# A1 in Northumberland: Morpeth to Ellingham

## **Annex D - Environment Agency Meeting Minutes Geomorphology**

**Annex D - Environment Agency Meeting Minutes Geomorphology**

<b>PROJECT NUMBER</b>	70044136	<b>MEETING DATE</b>	10 December 2020
<b>PROJECT NAME</b>	A1 IN NORTHUMBERLAND: MORPETH TO ELLINGHAM	<b>VENUE</b>	MS Teams
<b>CLIENT</b>	Highways England	<b>RECORDED BY</b>	NB
<b>MEETING SUBJECT</b>	Discussion of 2D modelling approach to answer Relevant Representation queries (geomorphology)		
<b>PRESENT</b>	[REDACTED] – WSP; [REDACTED] – WSP; [REDACTED] – WSP; and [REDACTED] – Environment Agency		
<b>APOLOGIES</b>	<a href="#">Click here to enter text.</a>		
<b>DISTRIBUTION</b>	As above		
<b>CONFIDENTIALITY</b>	Public

Figure 1-2 – Parameter 10 – Extent of Pier Movement to the North

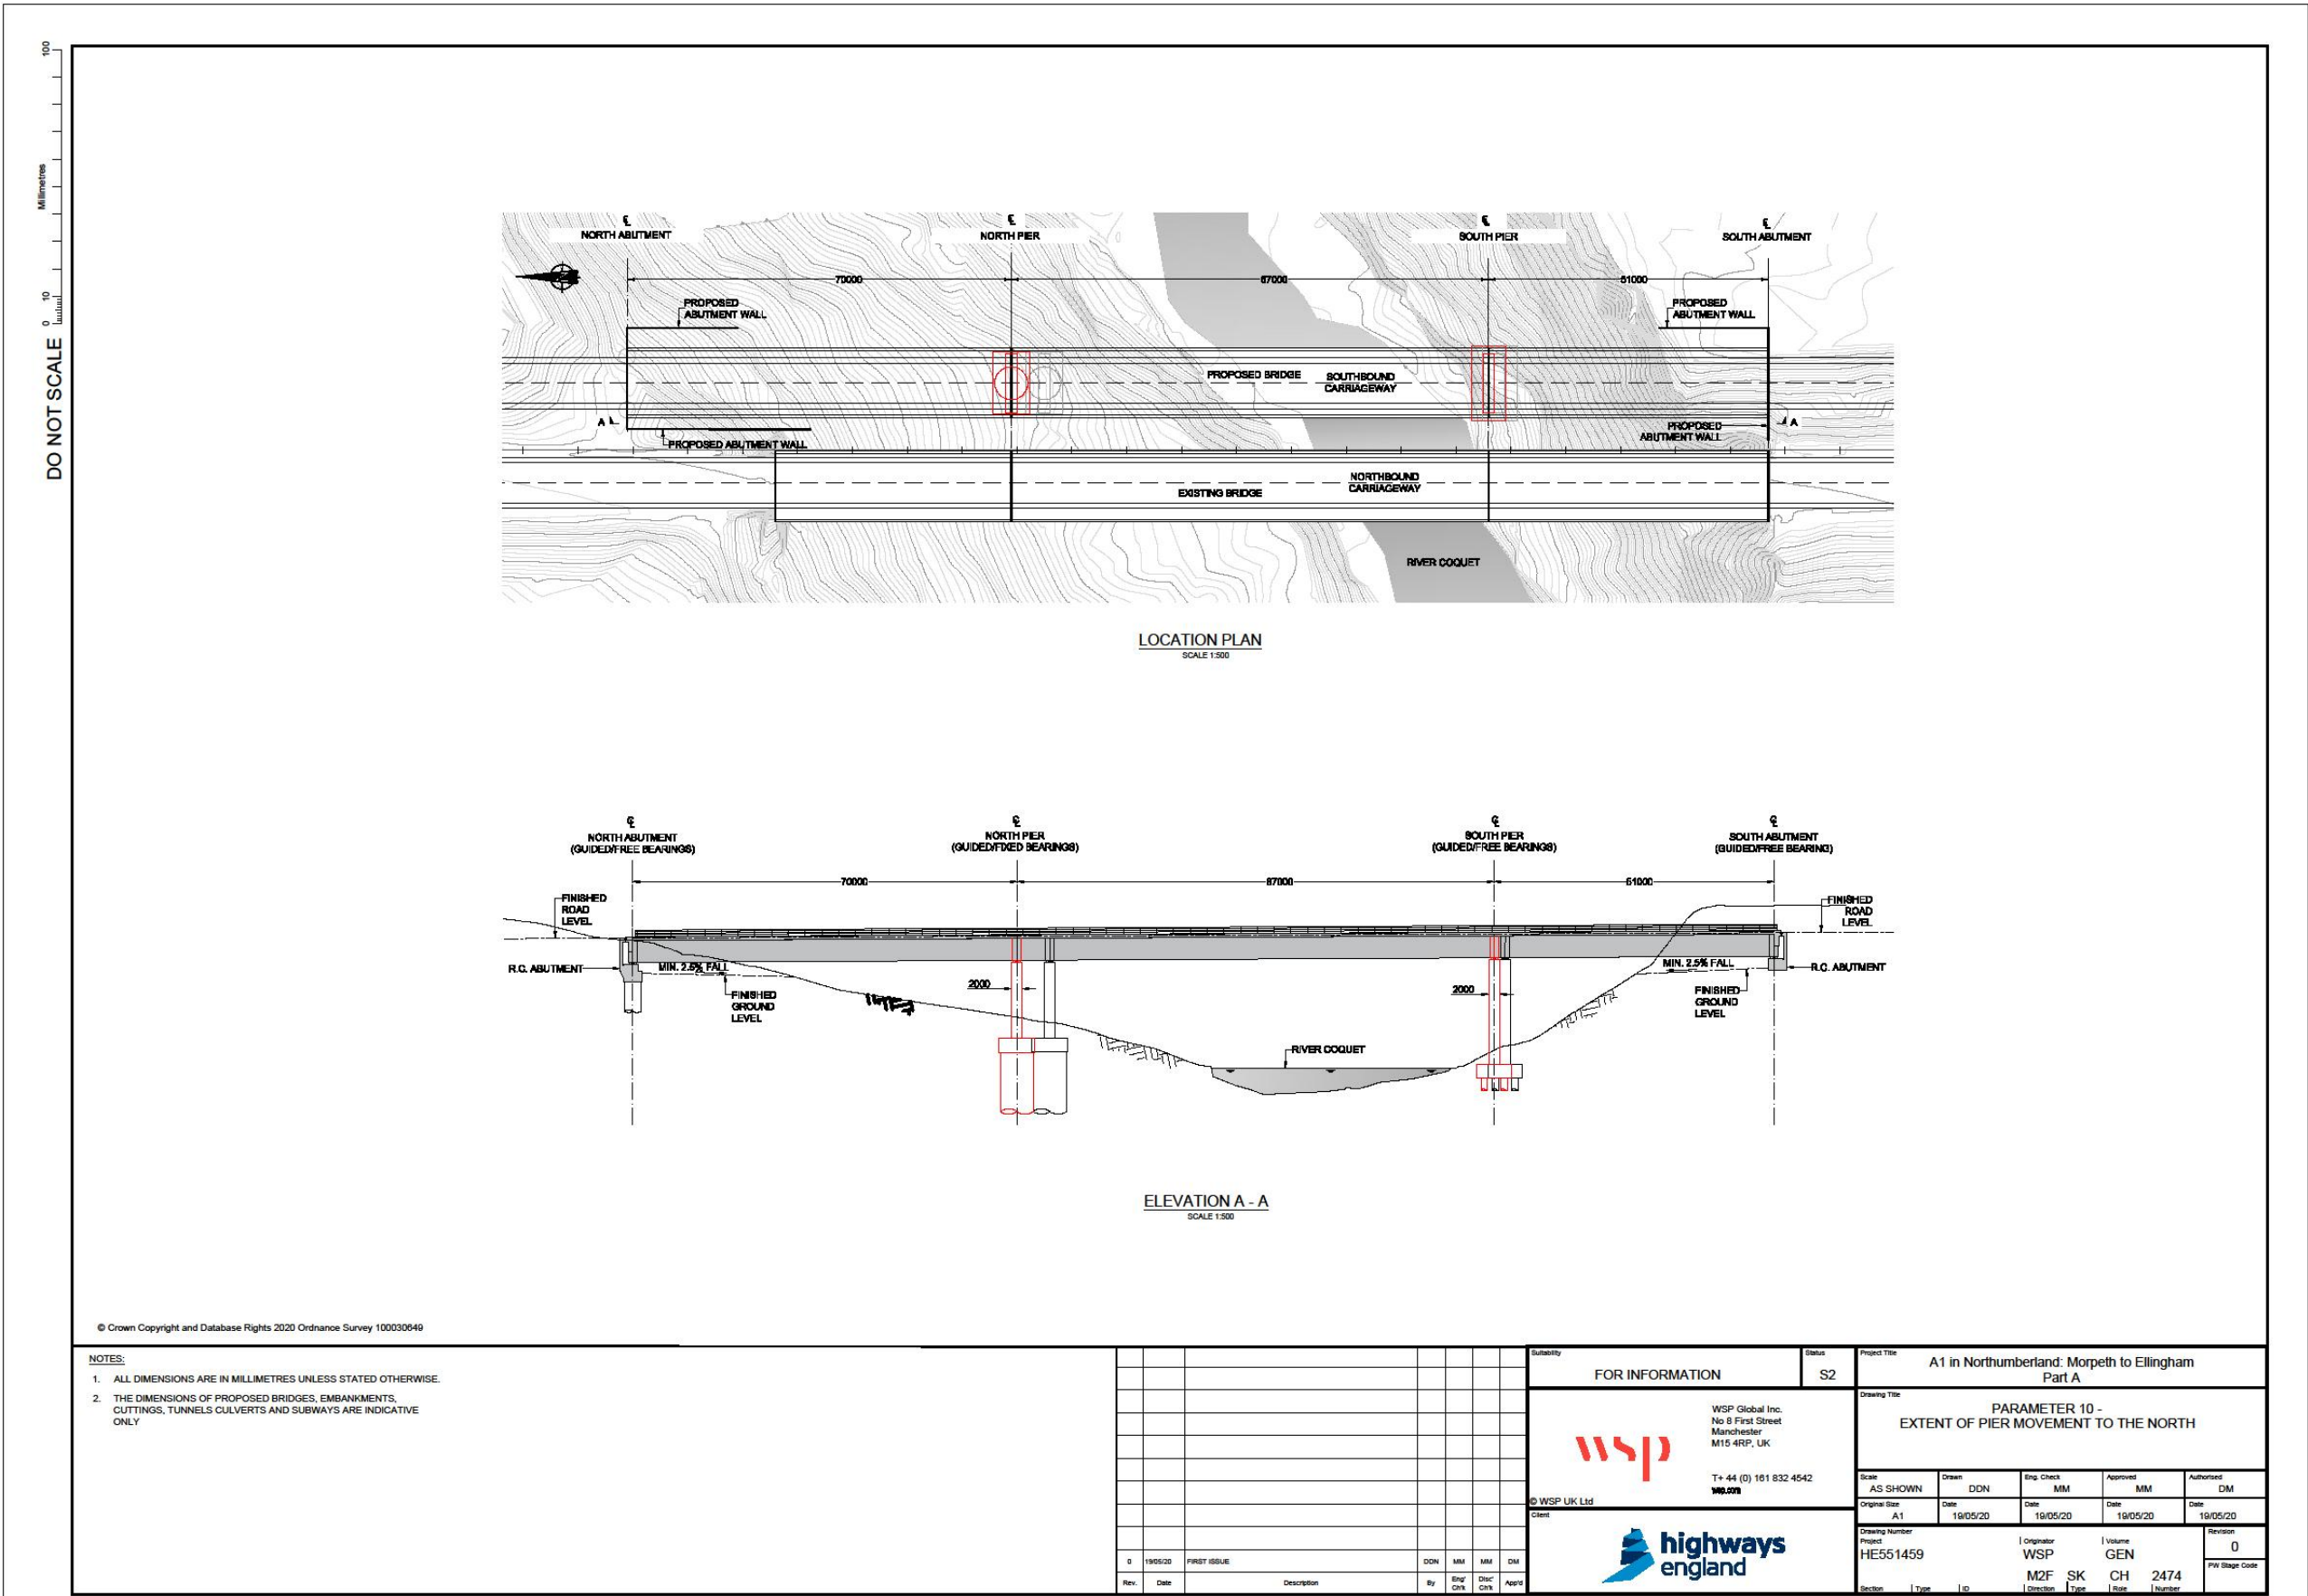
ITEM	SUBJECT	DISCUSSION
1	Clarity of the cross section used to produce the physical parameters such as channel width, area, wetted perimeter, hydraulic radius. The cross section needs to be accurate, to scale,	[REDACTED] explained that 2D modelling is now being proposed to assess impacts of the scheme and to provide robustness to previous analyses, rather than continuing with the cross-section approach.

and must show the 4 scenarios and the levels of the 7 flow regimes;	The cross-section will also be provided to ■■■ as part of the slide pack prepared for this meeting along with its location transposed onto a plan.
2	Relying on the 1 cross section to generate the conclusions feels weak. Further cross sections up stream of and downstream of the new pier will create a much better picture, and more confidence in the findings	WSP team in agreement, hence development of 2D model. Limitations of using LiDAR were discussed but ■■■ agrees that this approach is preferable to using single cross section for analysis.
3	Clarity on the flow data used. How were the numbers for velocity and discharge derived? What is the reasoning behind using a 485 and 525 yr flow, why no 100yr flow. The description of mean flow, Q10 and Q5 in the executive summary appears to be different to the flows used in Table 4.3;4.	■■■ explained that flow data was generated for purposes of flood risk assessment. ■■■ explained that hydrology has been developed for the 2D modelling. ■■■ confirmed that flows to be assessed are: 2, 10, 50, 100+cc and 200-year events.

**Figure B-2 - Sediment sampling transect locations within the Riffle-bar Reach**

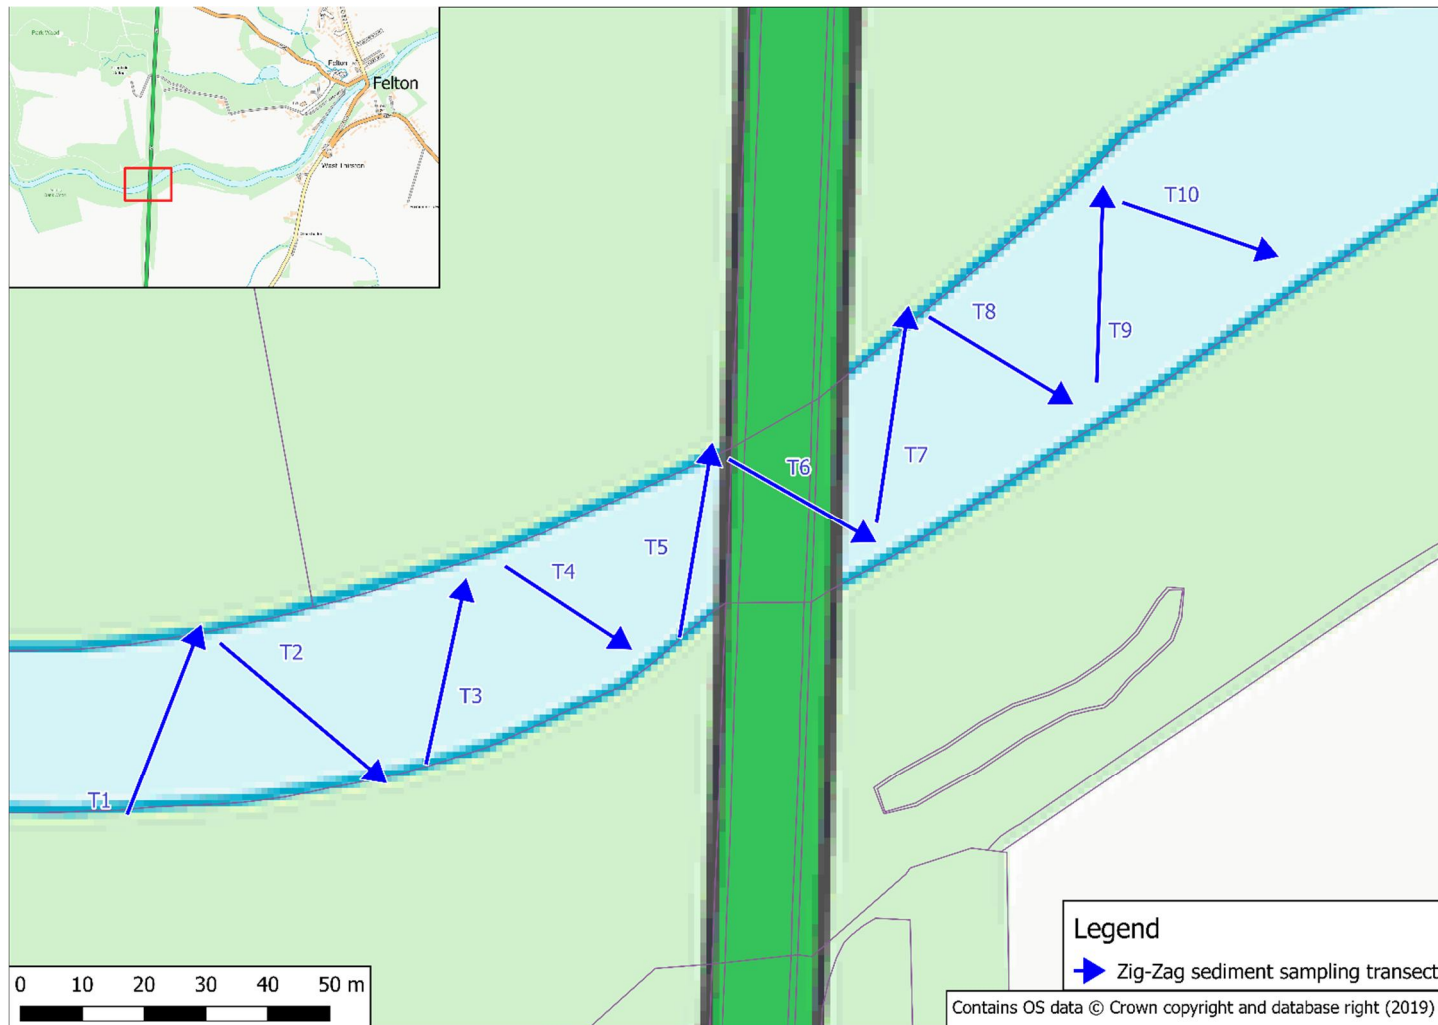
For the Parameter 10 report, the hydrological data was provided by ■■■, who had used a single value. Due to time constraints for completing the Parameter 10 assessment, it was not feasible to have the calculations re-run and meet the submission deadline.
5	The data collected during the sediment analysis does not truly reflect the composition and makeup of the mobile sediment within the reach. The inclusion of bedrock in the sediment analysis massively skews the results. The sediment analysis needs to focus on mobile sediment rather than the makeup of the bed;	Sediment data were explained and justified with photos of bar features. ■■■ discussed use of D16, D50 and D84 across the full suite of flows for robustness/completeness. ■■■ happy with this approach.
6	The footprint of the sheet piling and the foundations of the pier will be greater than the pier itself. The impact will be greatest during construction, has this been taken into account;	■■■ explained that sheet piling and working area will be modelled for full suite of flows. ■■■ explained that sheet piling will not exceed bed level once complete. ■■■ happy with this approach.  ■■■ will seek information on the construction period and the land take. ■■■ explained that some of this information may be high-level at this stage as it is often deferred to the Contractor.

Figure 2-3 - Areas with Modified Roughness Coefficient Values

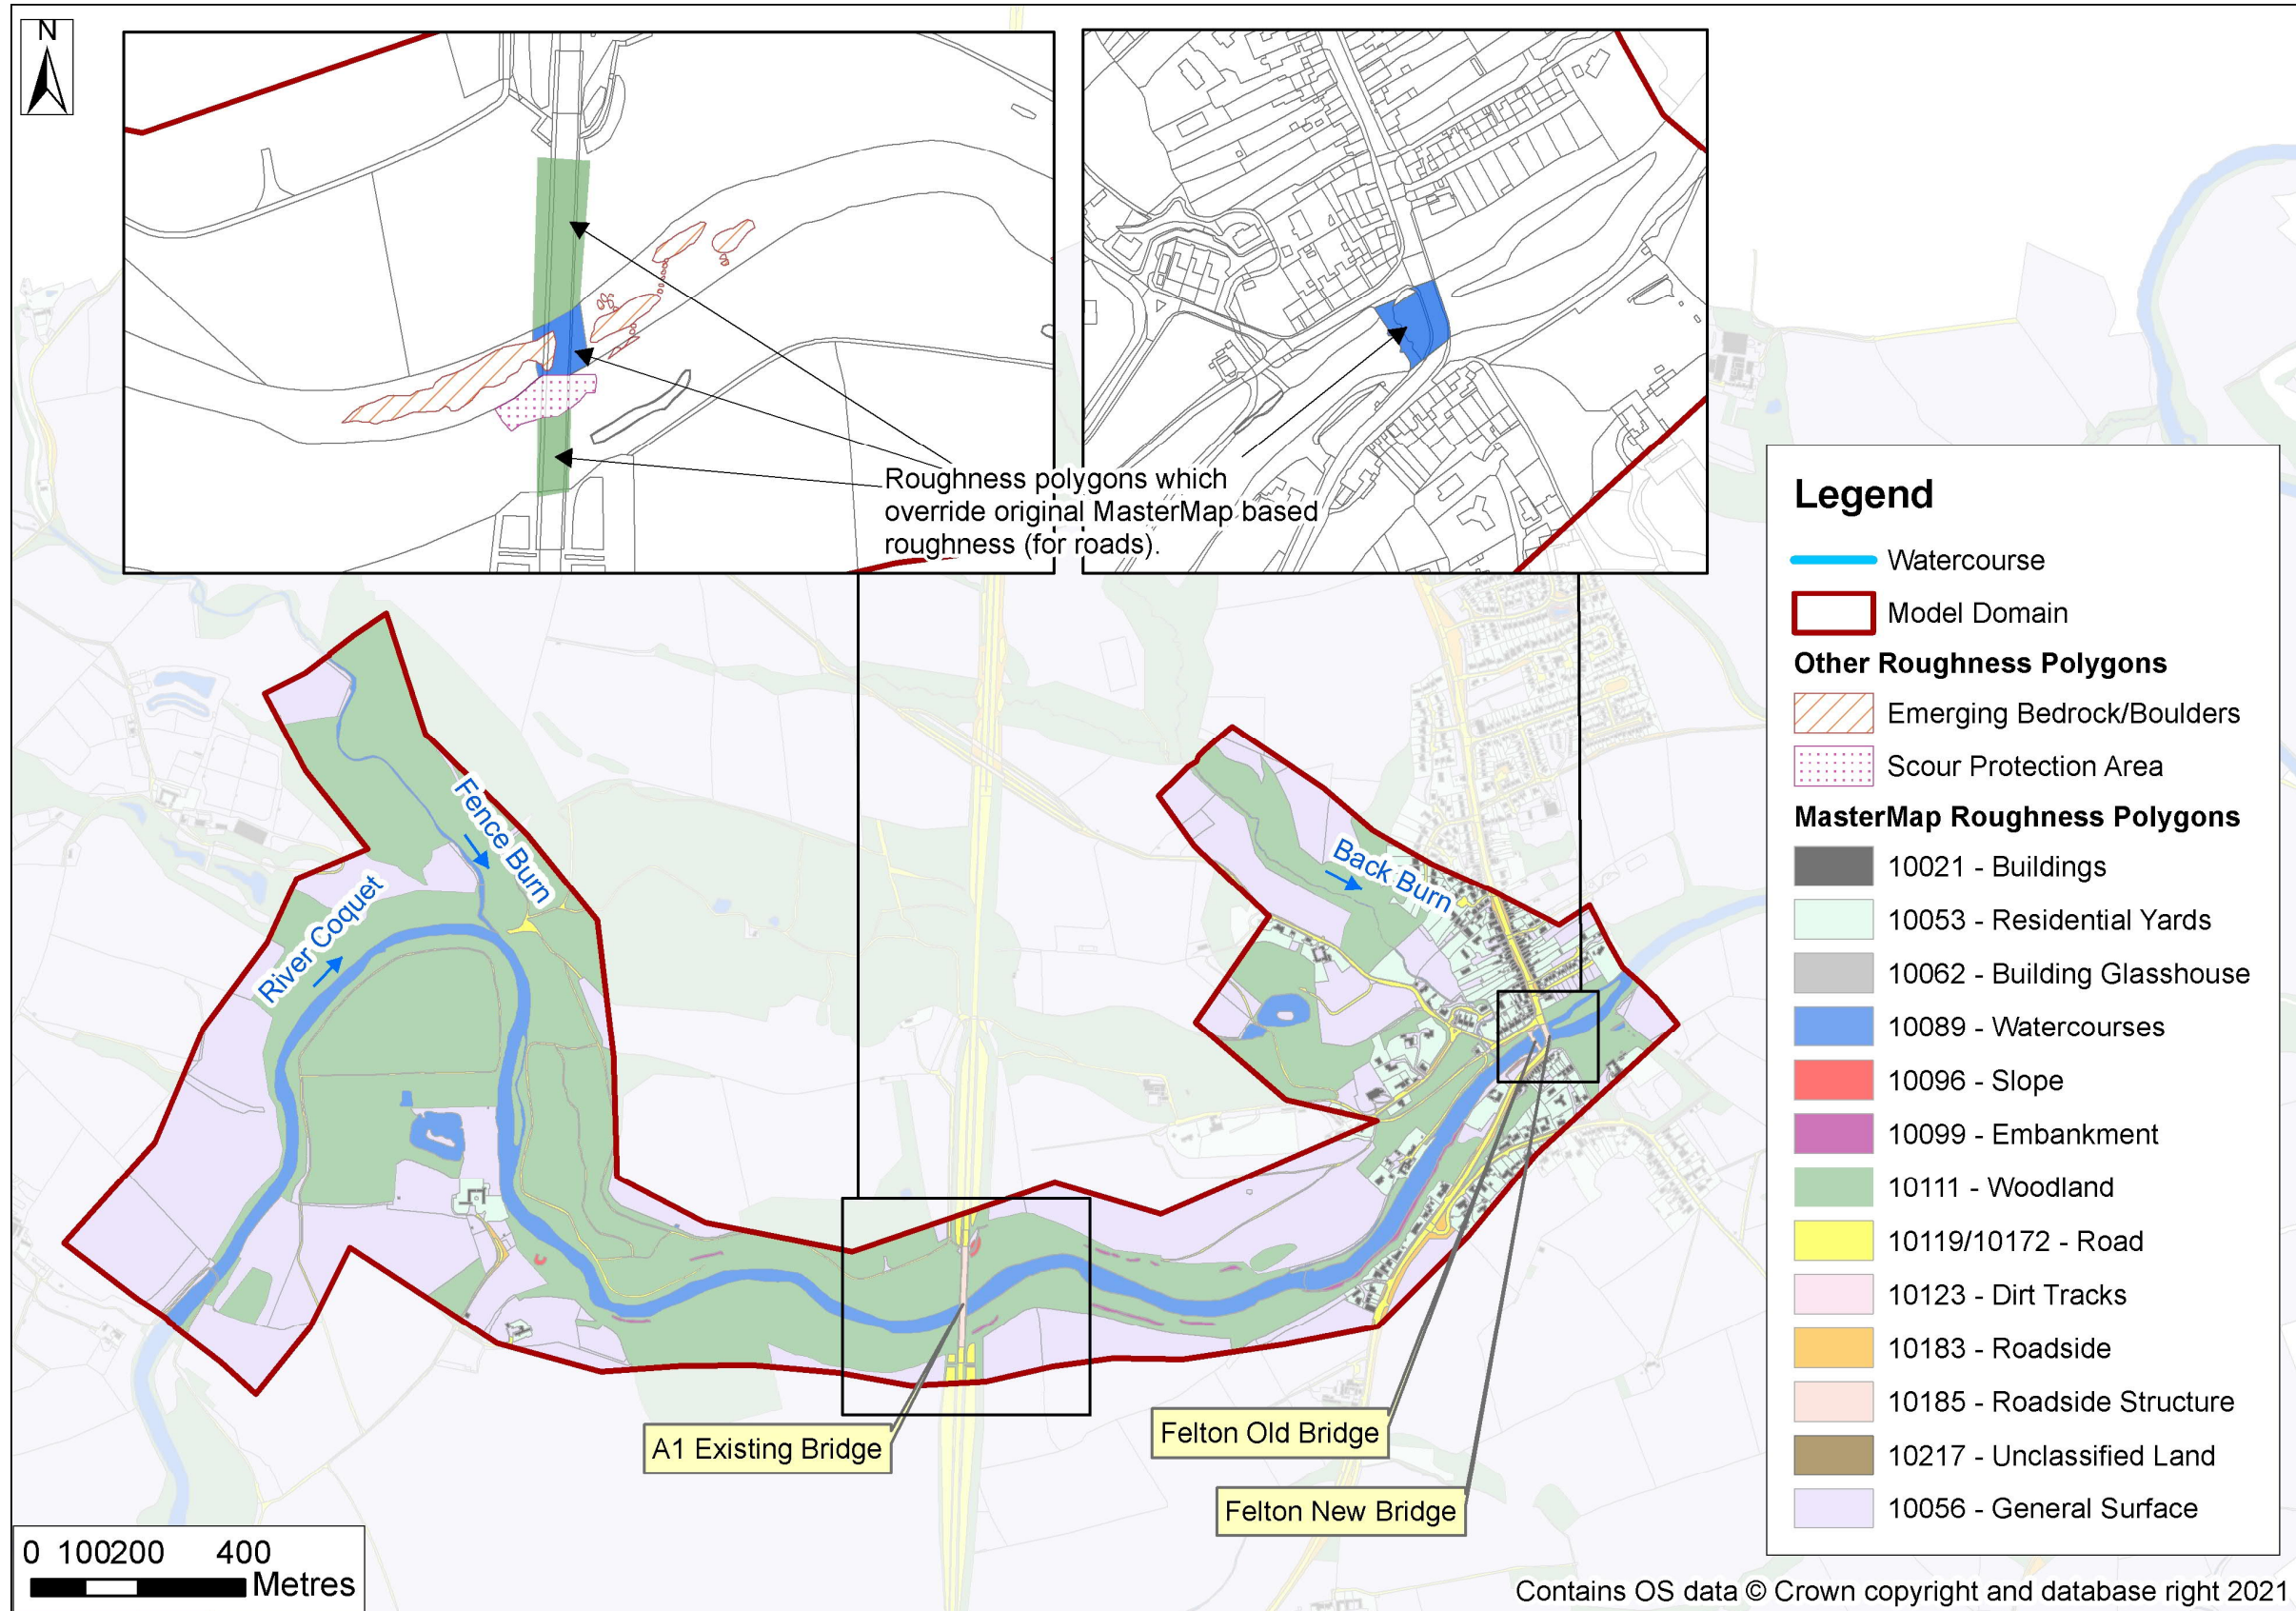
4	Rational for using a single manning's number for all scenarios. The number feels high for a bedrock channel, especially mid channel where the majority of the sedimentary deposits are located;	■■■ and ■■■ explained the inclusion of multiple Manning's values in the 2D model to better represent roughness. ■■■ happy with values. ■■■ confirmed that a sense check on highest flow would be carried out.  ■■■ also provided further explanation of why a mix of Manning's values were used in the initial assessment report and a single value in the Parameter 10 report. The first report the Manning's values were set by the WSP geomorphology team with different values used to reflect out-of-bank flows for baseline, proposed and the construction phase.
